24 May 2019

Modification 1 to concept approval for UTS Blackfriars Precinct Research Building, Chippendale (SSD 6746)

Graham Jahn AM
Director
City Planning | Development | Transport

## 1.8 Proposed Planting

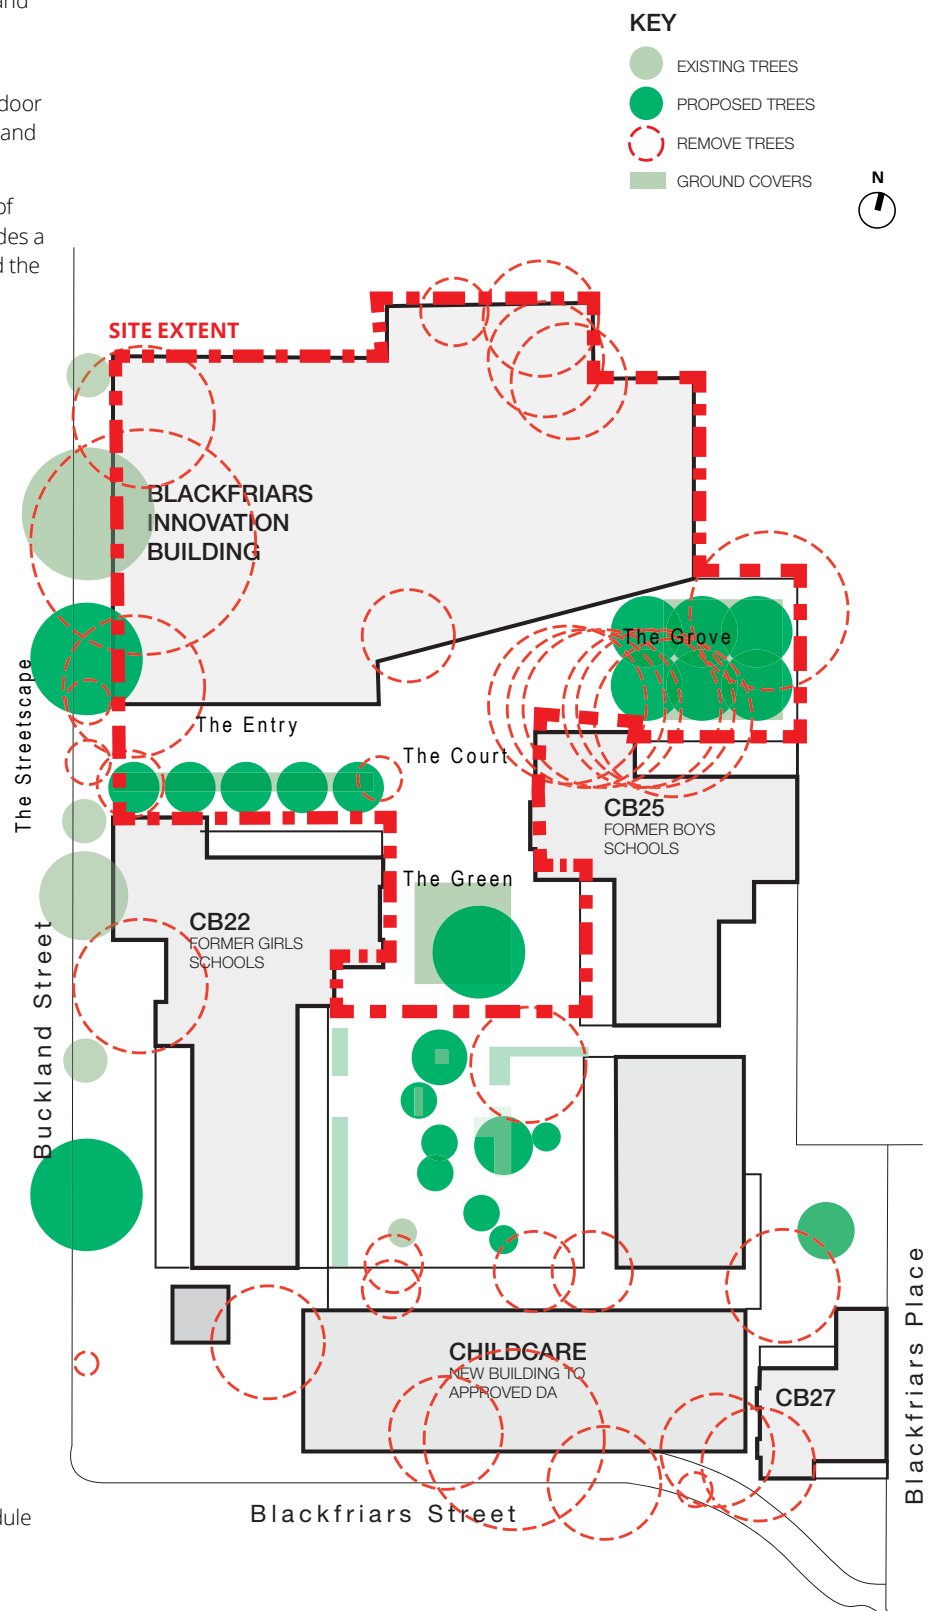
It is understood that while the reduced western setback to Buckland Street requires removal of three existing trees, replacement with advanced species is proposed elsewhere within the site, which is supported in principle. The applicant is requested to carefully consider where those trees are sited at the detailed DA stage so that views of significant buildings are not obstructed. It is also noted that there is existing extensive tree cover along Buckland Street so removal of three trees within this western setback will not overly diminish the existing streetscape character.
